Preliminary Acceptance (PA) Punchlist
EPC - DPW - Stormwater Section

| Project Name: | Dwire Storage Yard |
| Date of Walk-Thru: | 3/14/23 |
| Walk-Thru Number: | 2 nd |

DWIRE STORAGE YARD	
FULL SPECTRUM DETENTION POND SITE PLAN	
PROJECT NO. 43-117	DATE: 11/16/2020
DESIGNED BY: CMM	SCALE: HORIZONTAL: 1"=20'
DRAWN BY: CMM	VERTICAL: N/A
CHECKED BY: VAS	SHEET 2 OF 6
ST02

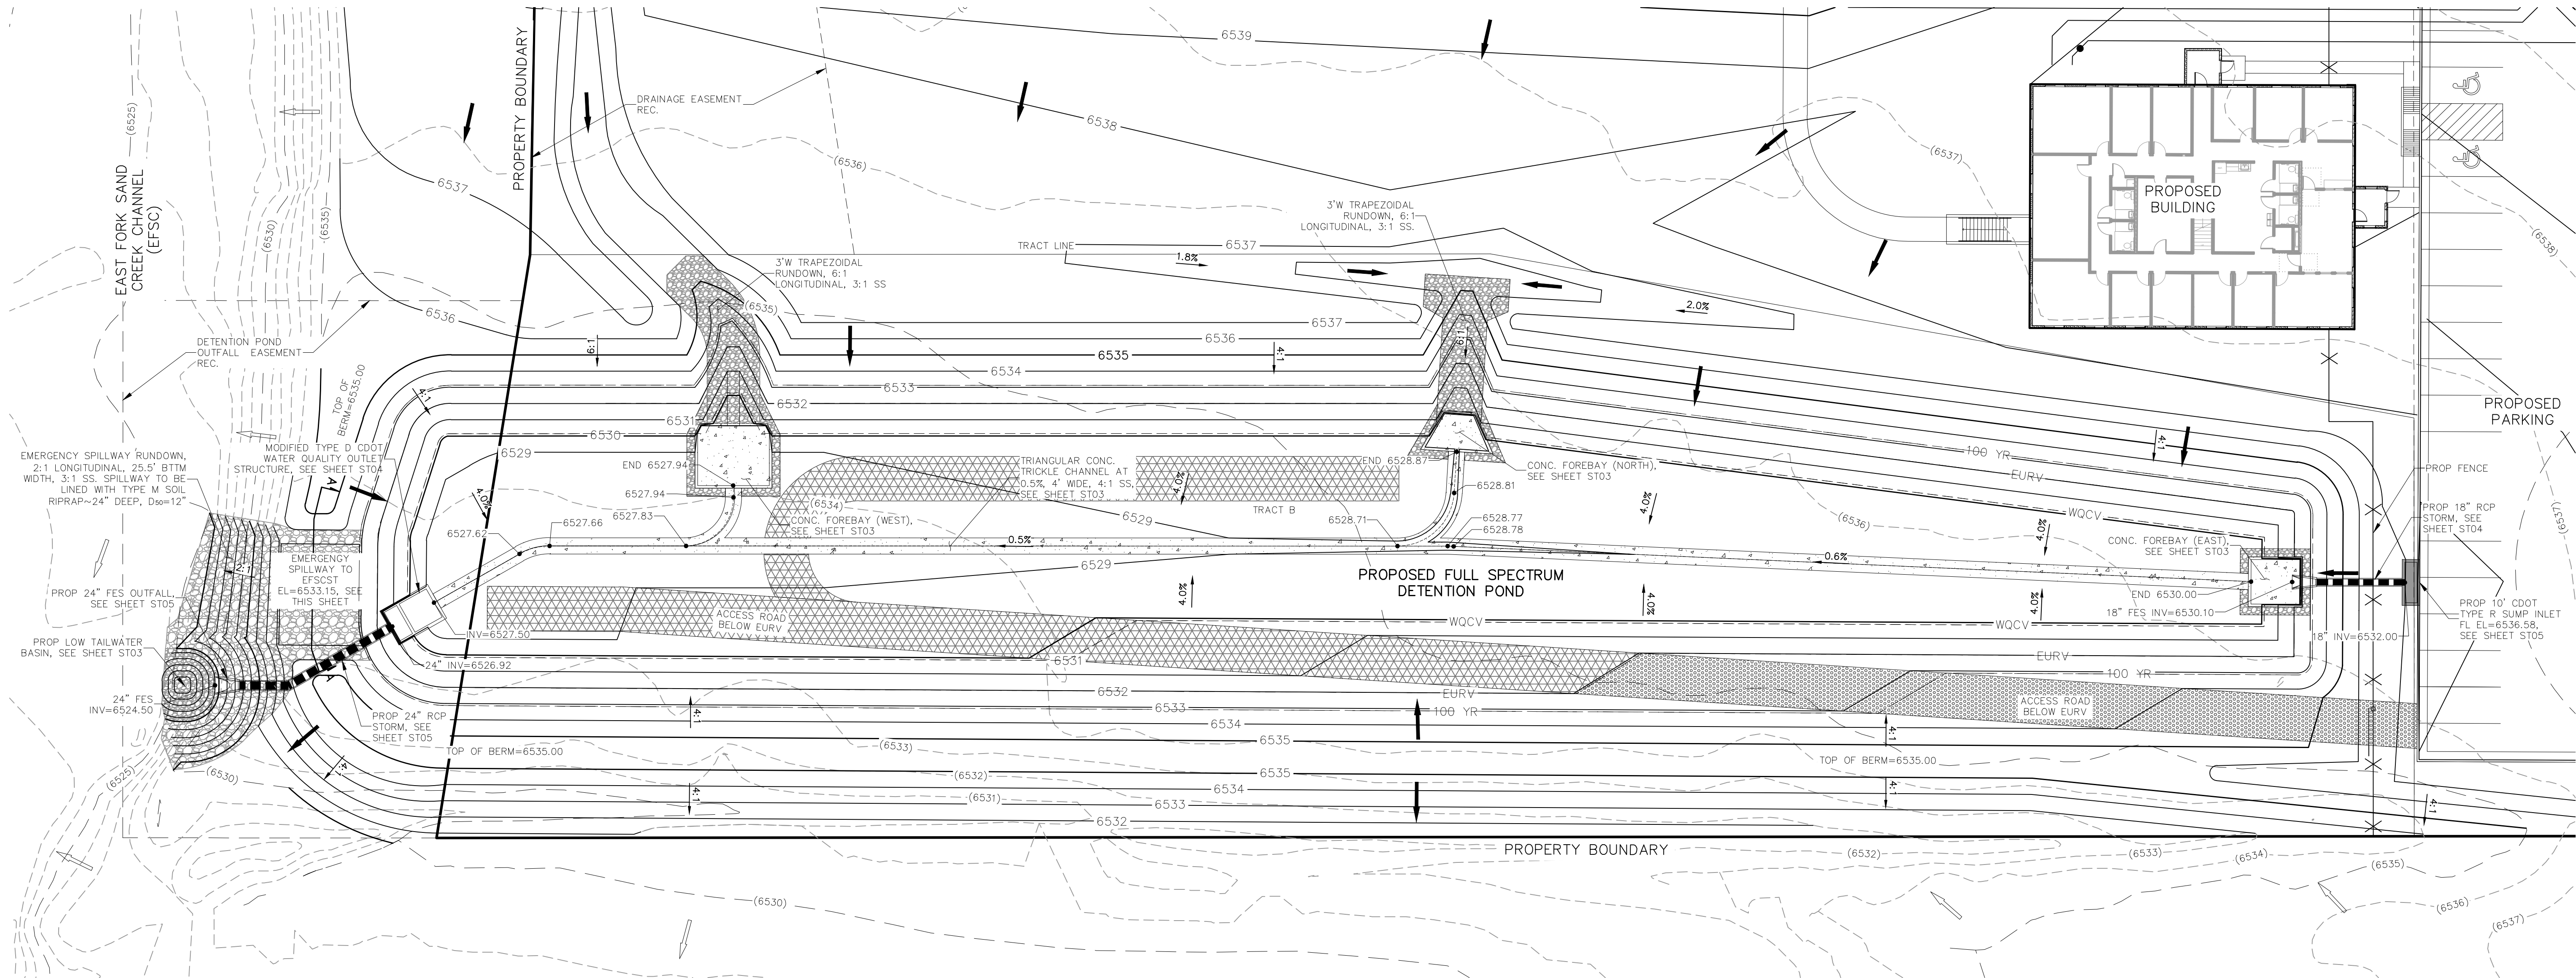
- Confirm with as-builts that Basin-OS4 drains to extended detention basin (see proposed drainage map in drainage report and refer to proposed flow arrows per plan sheet ST02.).

**SECTION A-A**  
NOT TO SCALE

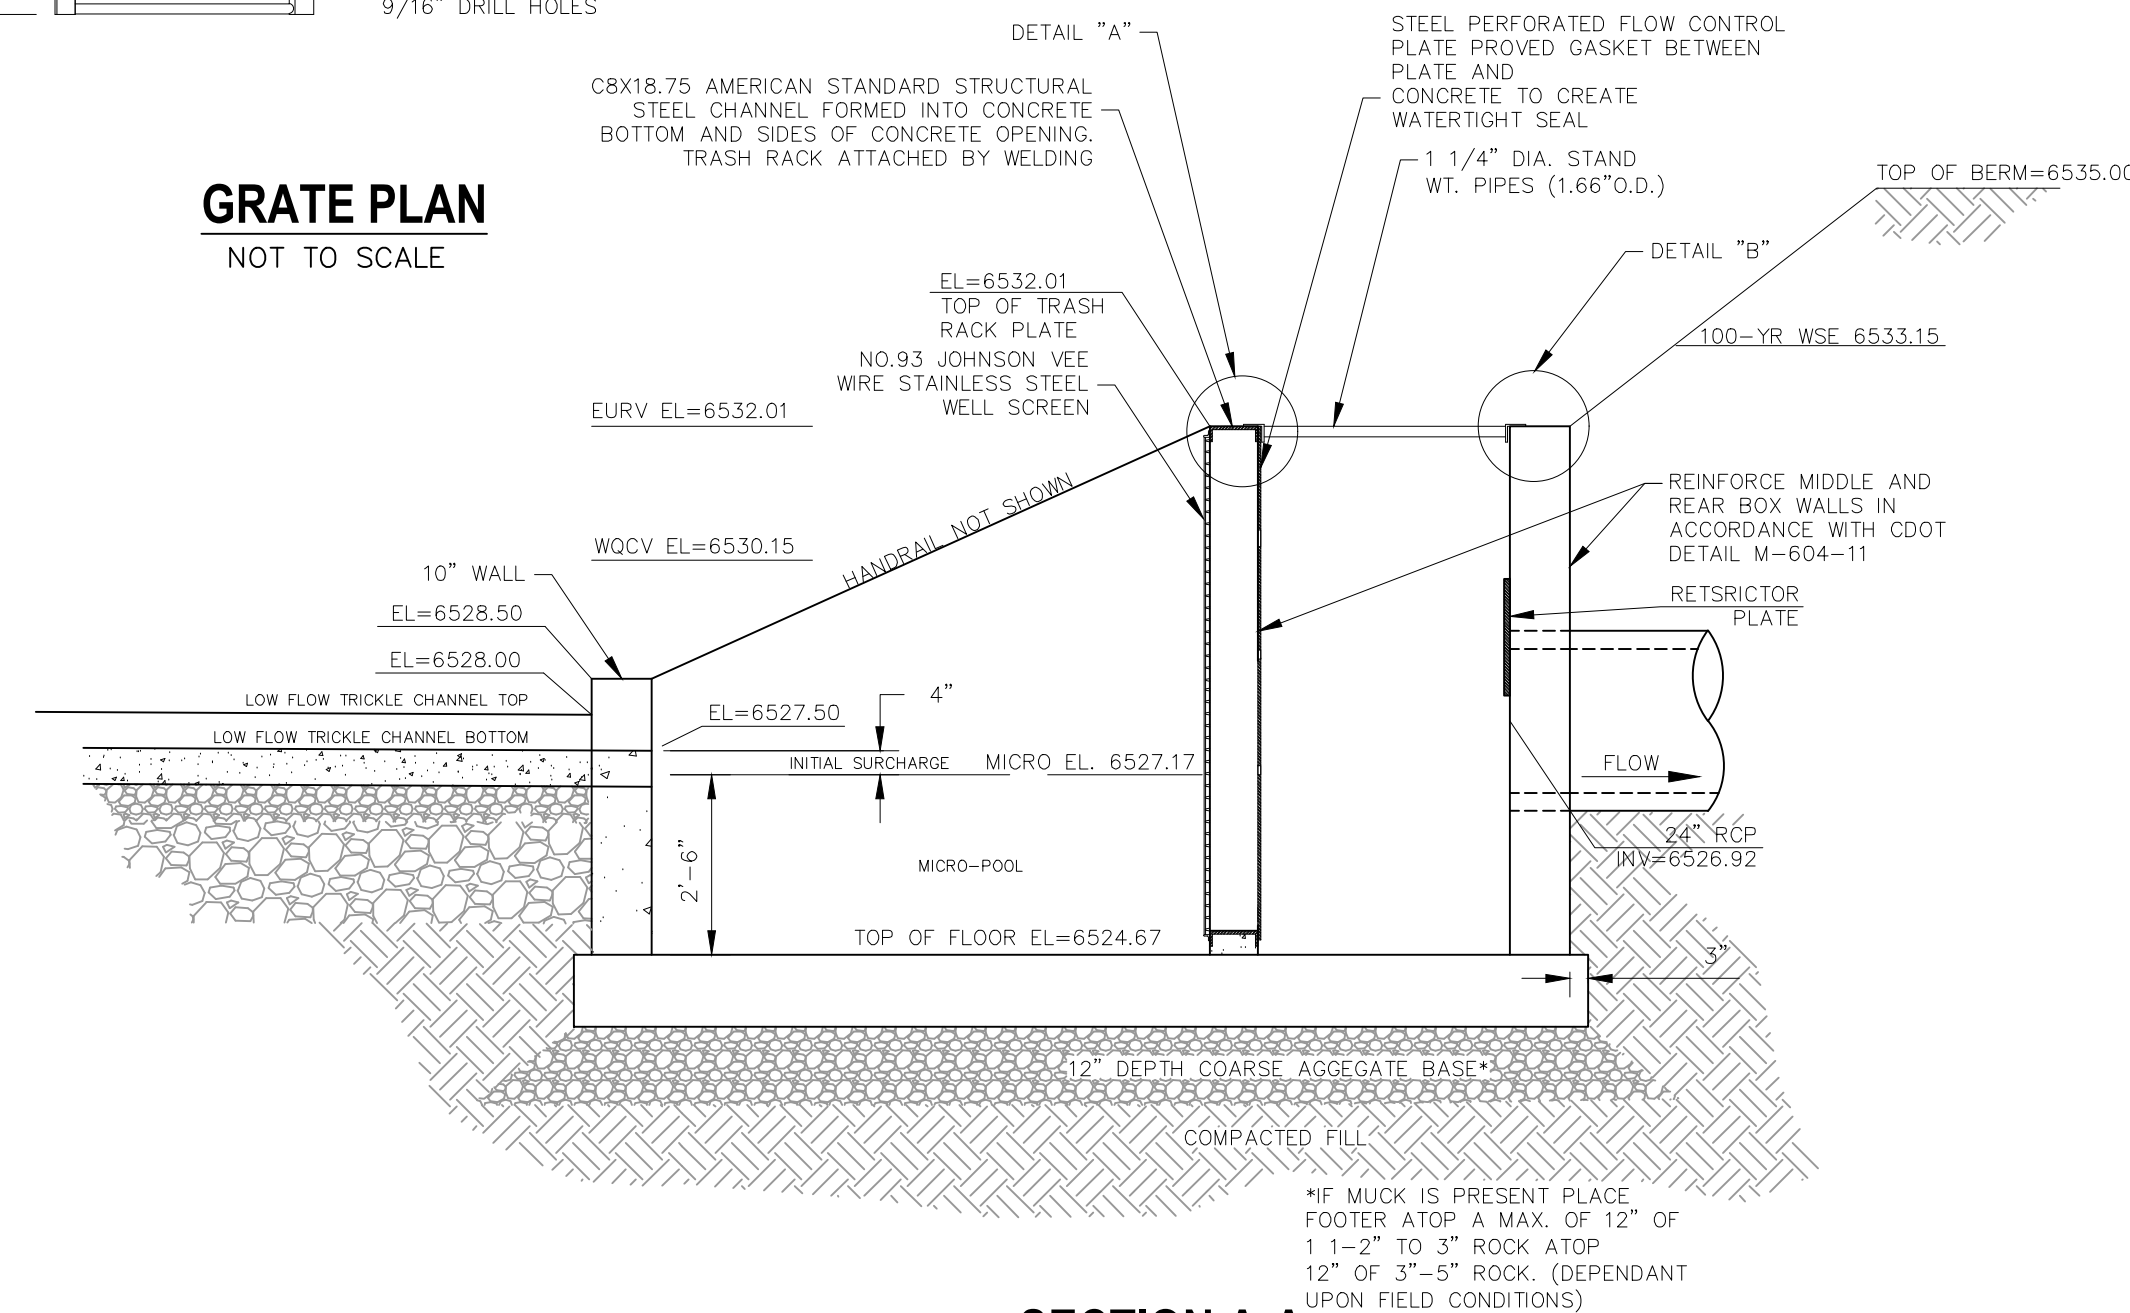
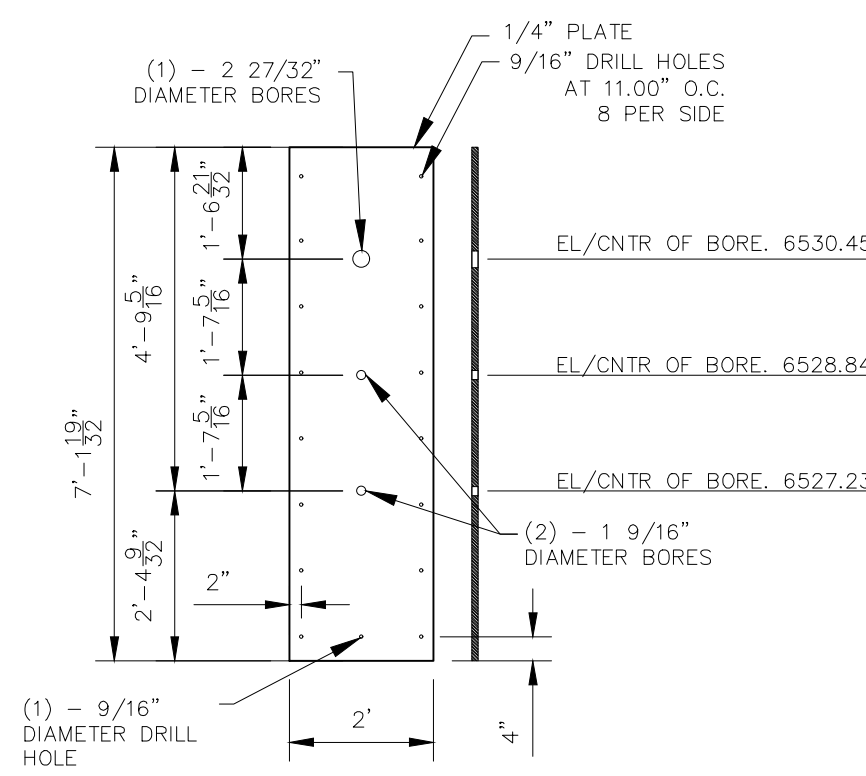
- Ensure gasket or caulk is installed at orifice plate per plan sheet ST04 (Section A-A detail)
- Repair erosion of swale (running N-S) on west side of project and implement final stabilization measures.
